## STOP LIME DOWN

## HERITAGE AND ARCHAEOLOGY REPSONSE

April 2026

Title:
Figure 12-2-1: Archaeological Assets:
Lime Down Lime Down A

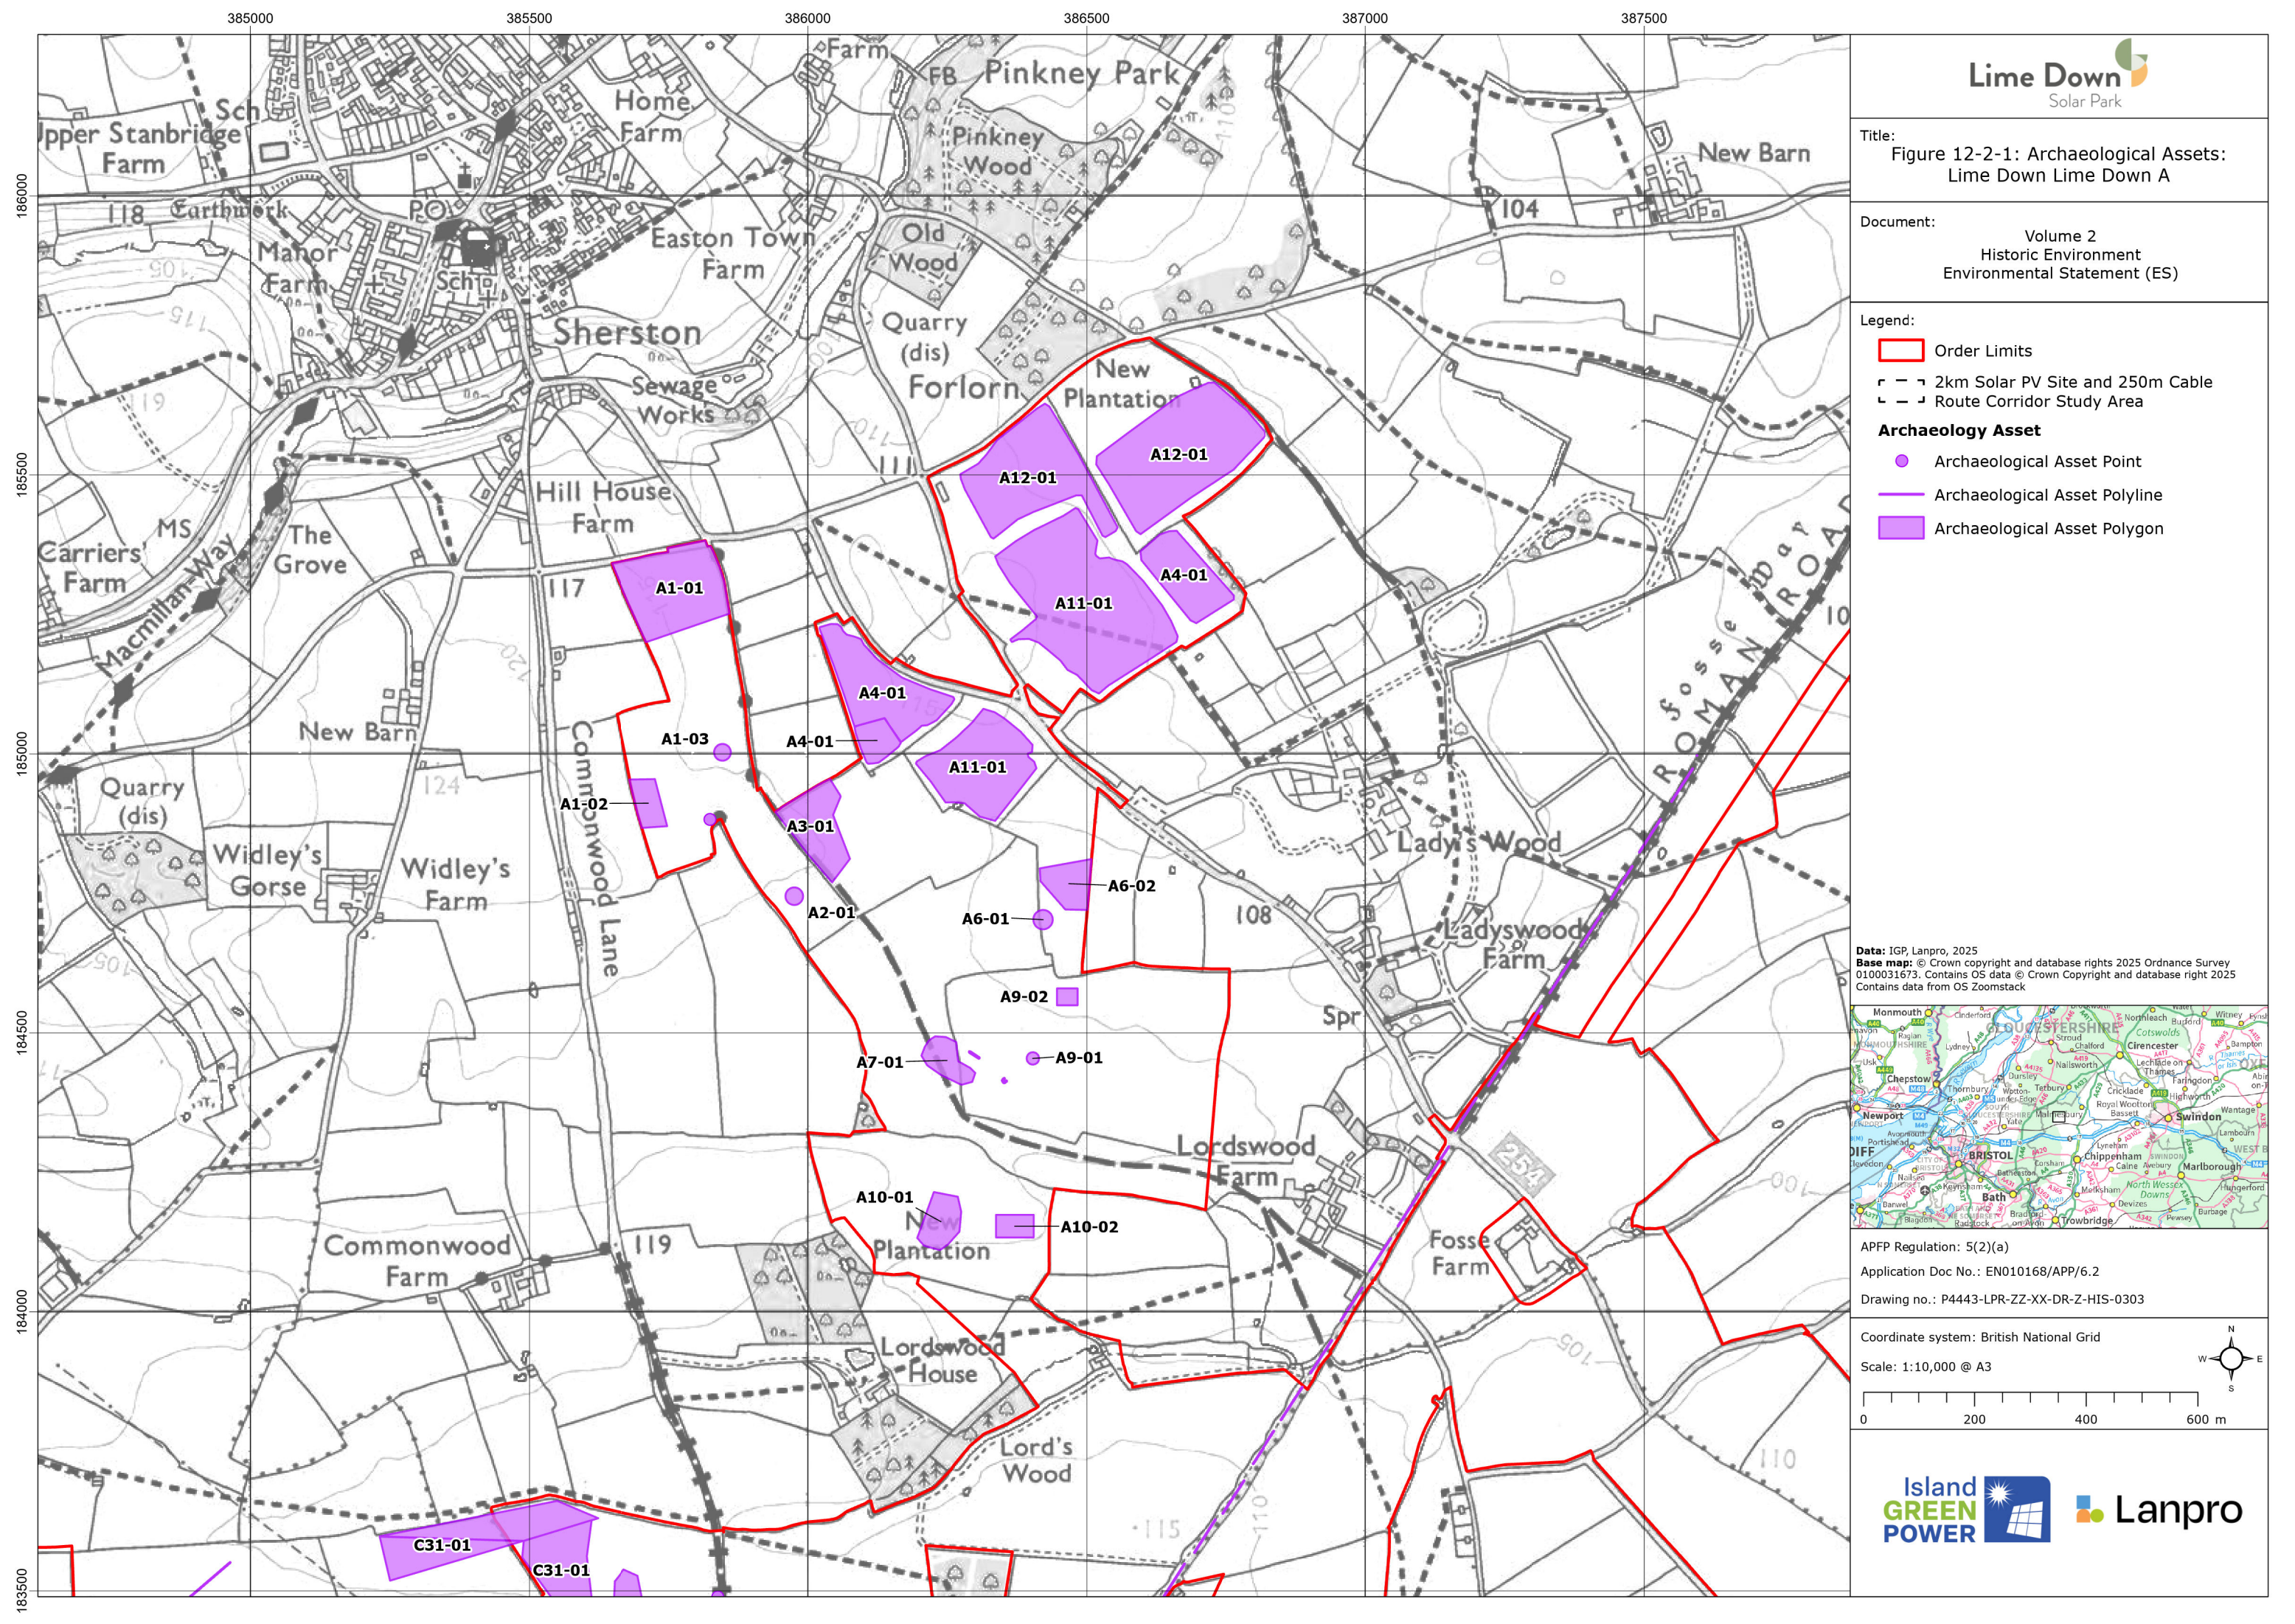
- 2.4 The area of the Site referred to as Lime Down A is located to the north of the Order Limits and incorporates the areas around Lordswood Farm and the Fosse Way.
- 2.5 The built heritage constraints of Lime Down A include the Grade II farm at Widley's Farm to the east of the panel and the Sherston Conservation Area to the north of the panel area.
- 2.6 Archaeological constraints of Lime Down A include potential Prehistoric and Roman settlement sites identified through geophysical survey [APP-223] and trial trenching [APP-225] to [APP-229]. We consider that the Applicant has failed to adequately assess the impact of the scheme on the relationship between possible Romano-British settlement sites and the Fosse Way, as well as the impact of landscape and ecology planting on buried remains within this works area.

Title:
Figure 12-2-2: Archaeological Assets:
Lime Down Lime Down B

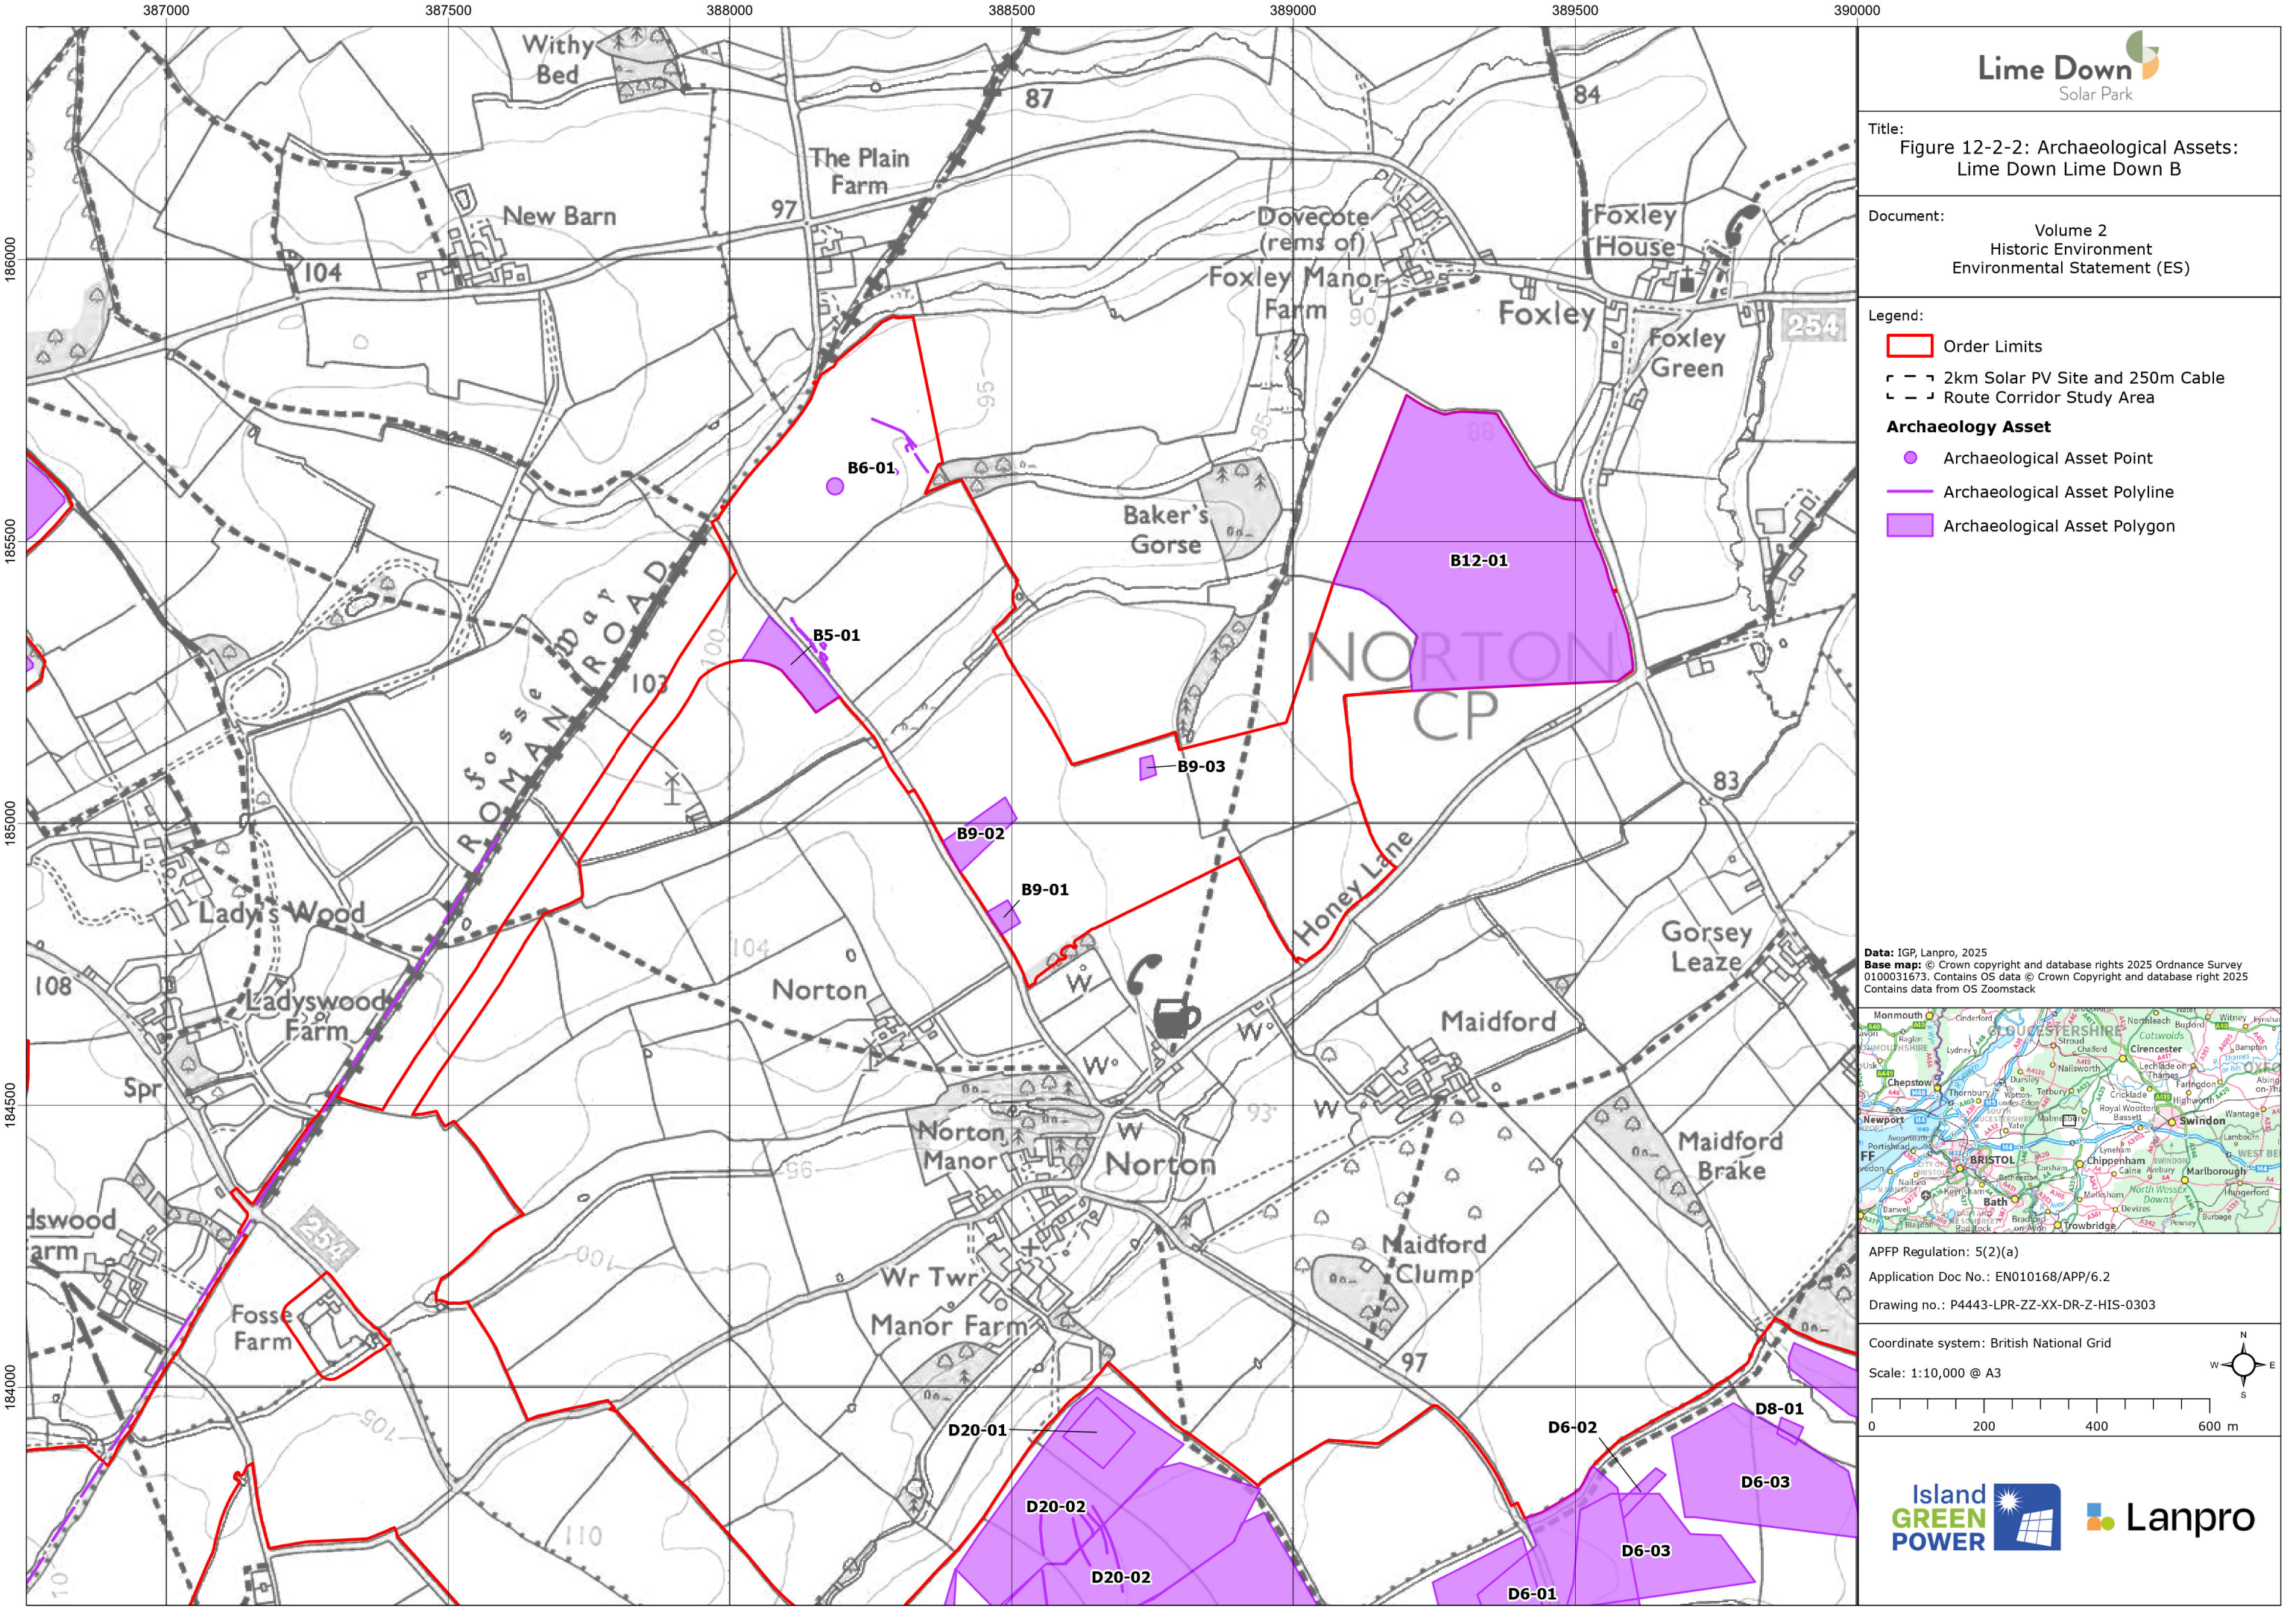
- 2.9 Archaeological constraints of Lime Down B include potential Prehistoric and Roman settlement sites identified through geophysical survey [APP-223] and trial trenching [APP-225 – App-229]. We consider that the Applicant has failed to adequately assess the impact of the scheme on the relationship between possible Romano-British settlement sites and the Fosse Way, as well as the impact of landscape and ecology planting on buried remains within this works area.
